This is to certify that Slm Properties Inc/Project M...t. Inc.
has permission to Office Fit-Up 2nd & 5 Flr
AT 241 Commercial St 038 F004001

Permit No: 03-1531	Issue Date:	CBL: 038 F004001
-----------------------	-------------	---------------------

Proposed Project Description: Office Fit-Up 2nd & 5 Flr	Signature: <i>[Signature]</i>	Signature: <i>[Signature]</i>
PEDESTRIAN ACTIVITIES DISTRICT (P.A.D.)		
Action: <input type="checkbox"/> Approved <input type="checkbox"/> Approved w/Conditions <input type="checkbox"/> Denied		
Signature:		Date:

A VERTICAL SUPPORT @ STOREFRONT GLASS  
 201 1"=1" (FULL SCALE)

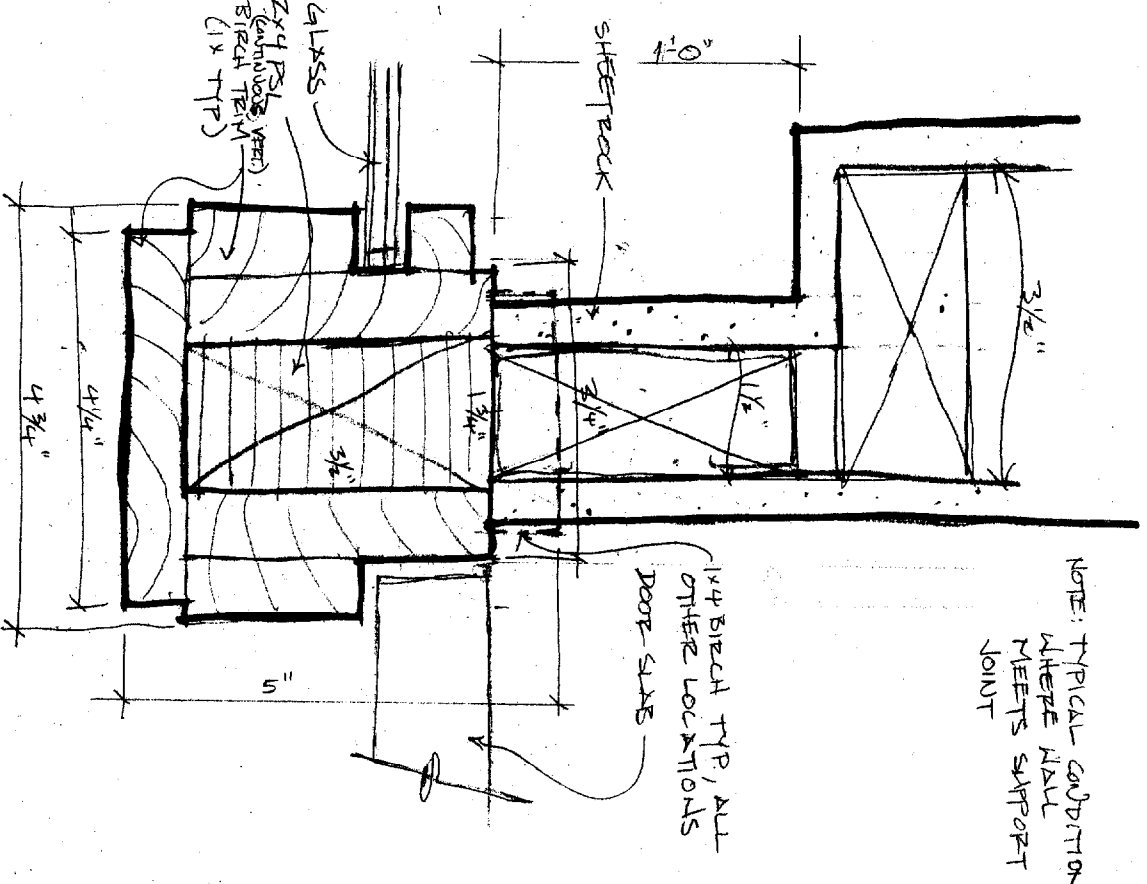
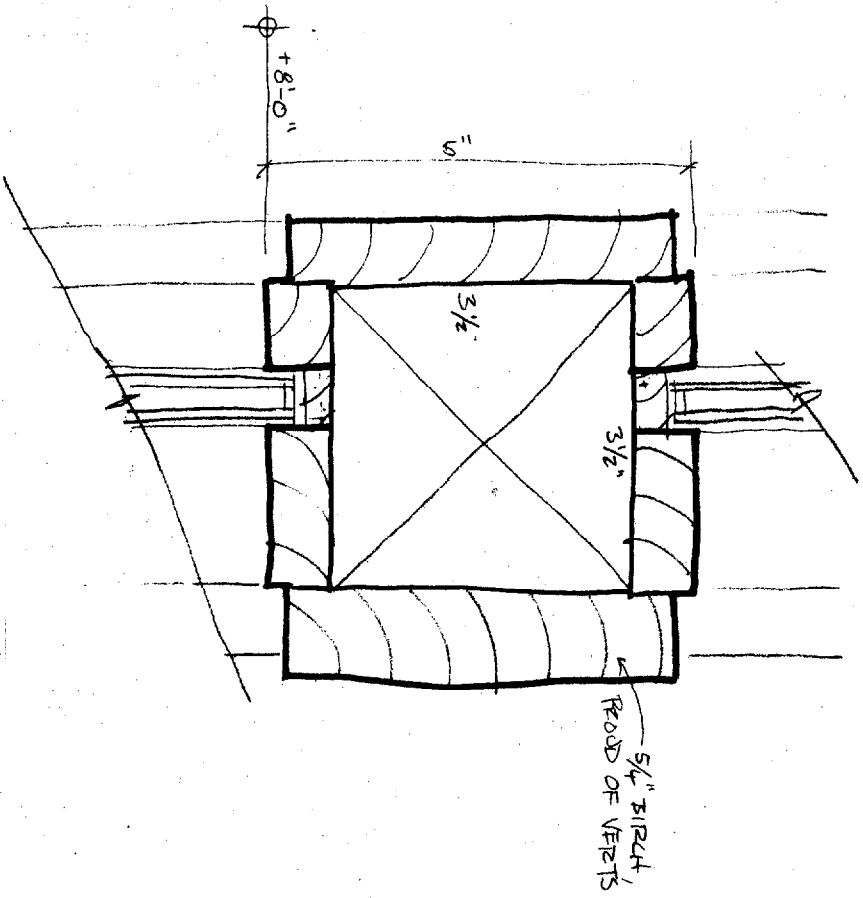
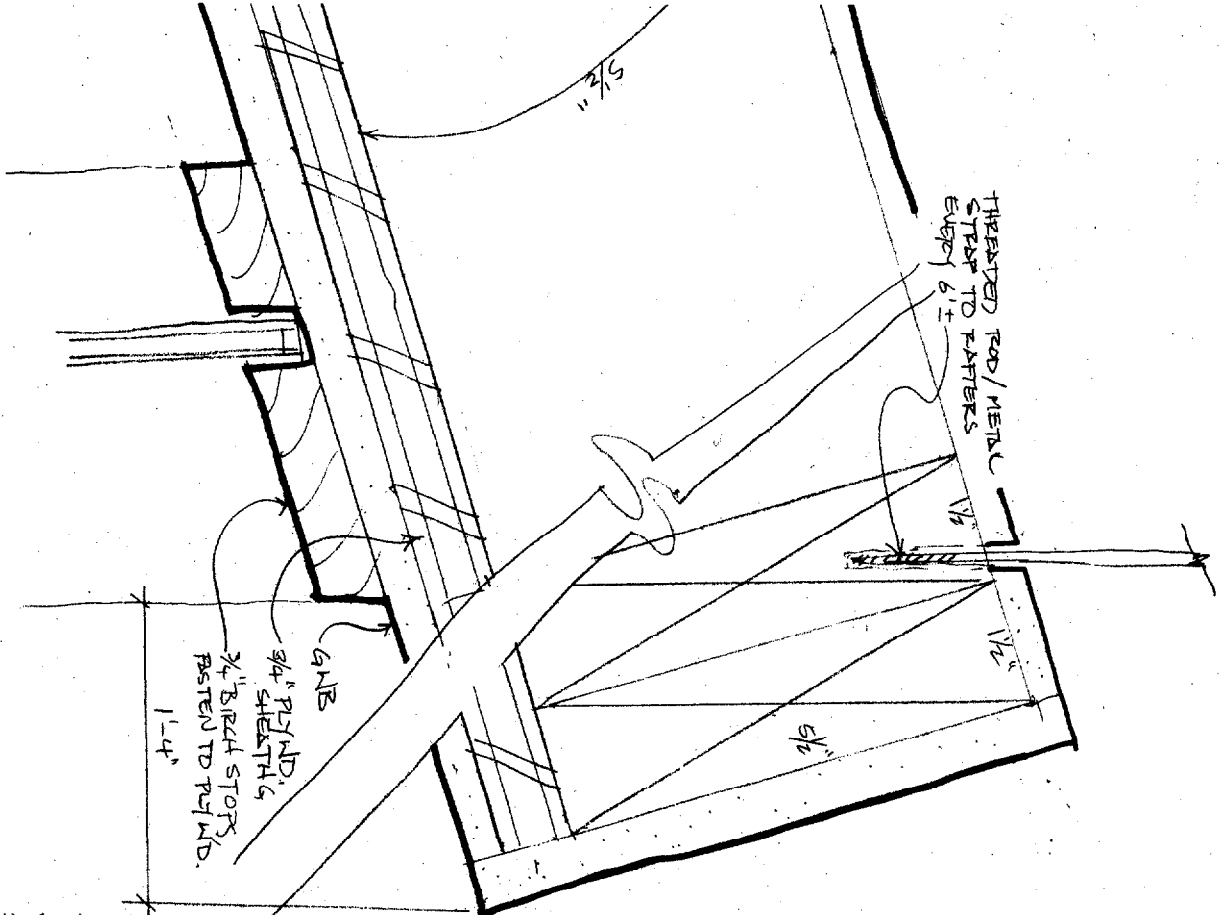
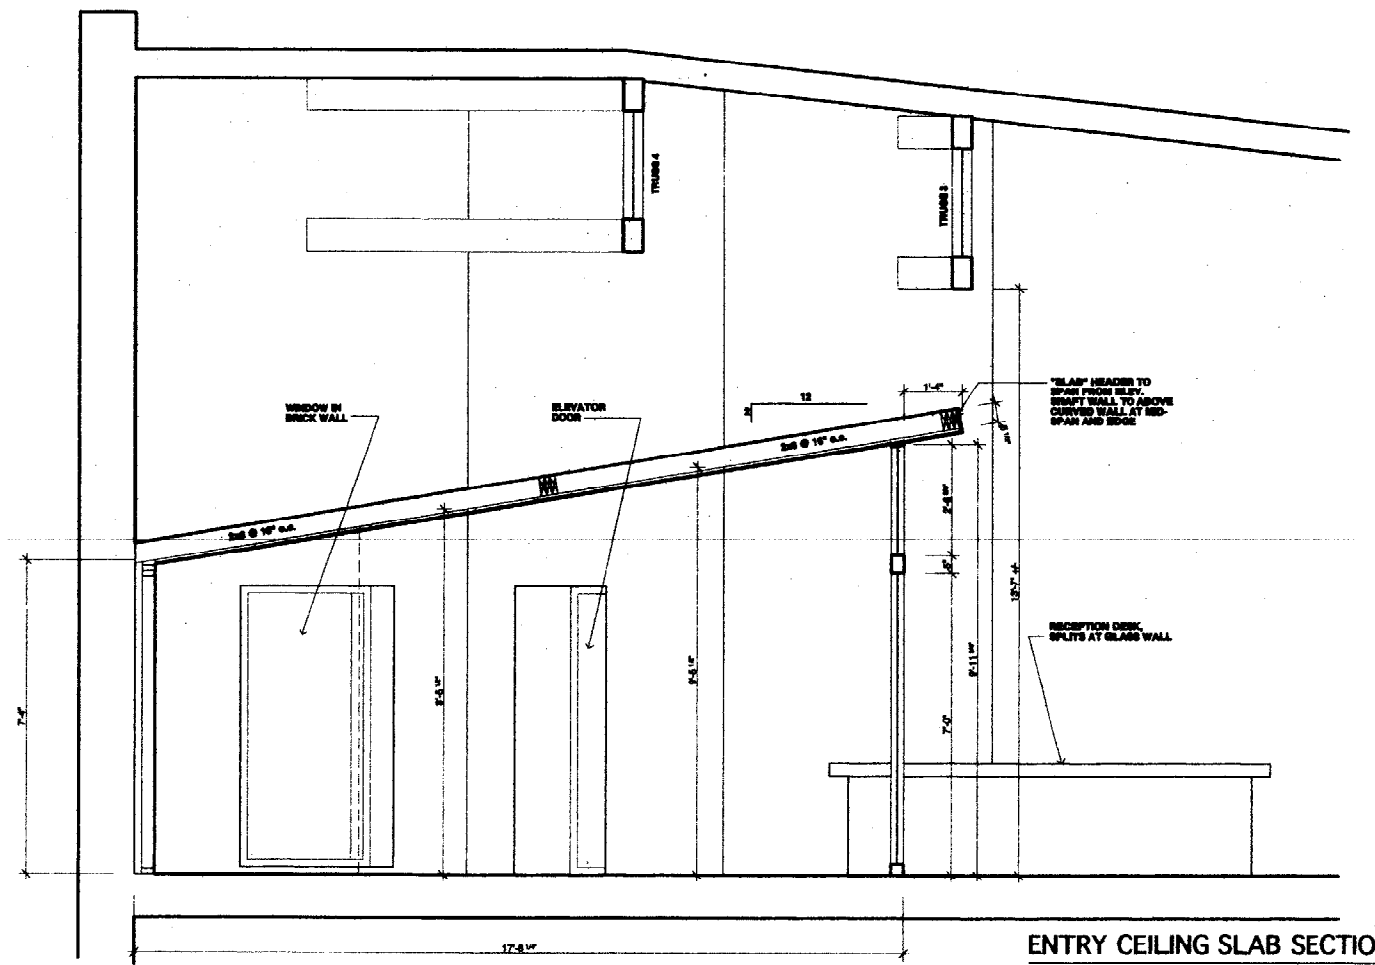
1/6/2004-mjn: Need info on glazing on 5th floor, architect notified

*NOTE: ALL GLASS TO BE TEMPERED OR LAMINATED,
ENTIRE STOREFRONT GLASS WALLS, INCLUDING
POORS.

SK1: Details of the window wall
